Application No: FP/224/20/HH
Site Address: 57 Minton Road Felpham PO22 7JX
Description of works: Two storey side and rear extensions to existing dwelling & replacement of existing front loggia.

Thank you for your internet representation made on 23rd December 2020 which has been recorded as an objection with the comments as follows:

DRAWING
**ELEVATIONS
PROPOSED**
DRAWING No
323/05
REVISION
SCALE 1:100
DATE OCT 2020
DRAWN LA
CHECKED

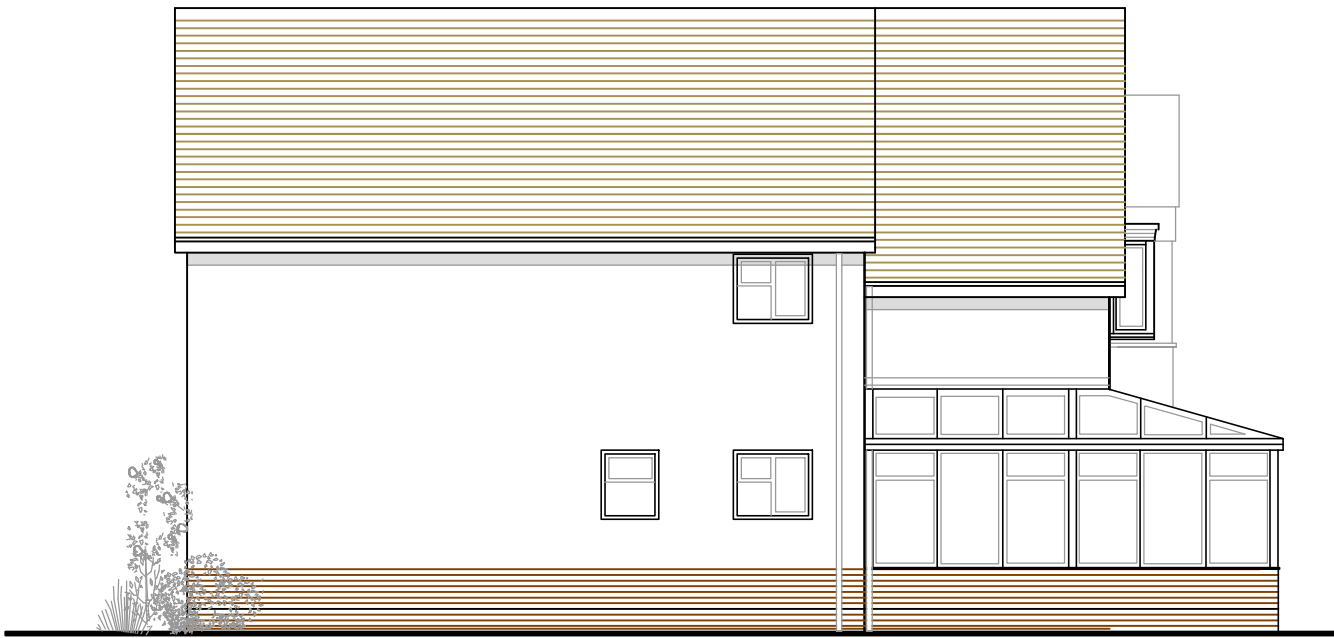
The impact of this plan on 59 Minton Rd will be significant. The "single storey" extension is directly on the boundary and since the roof rises to the full height of the property and extends over 4m North, it will significantly affect the light levels for much of the year in our garden, particularly the patio area adjacent to the house, which will feel much more enclosed due to the extended walled boundary and roof height. The westerly outlook from our dining/living area will also be blighted and the light in the study, which has a west-facing window, will be substantially reduced. The scale of the whole extension in relation to the current property is considered too large and overbearing and more impactful than other extensions on surrounding properties, which have developed laterally into space between properties. This plan would reduce the open aspect of the rear of the houses and adversely alter the character of this part of the development. The Eastern boundary should be shown on the 1:100 plans.
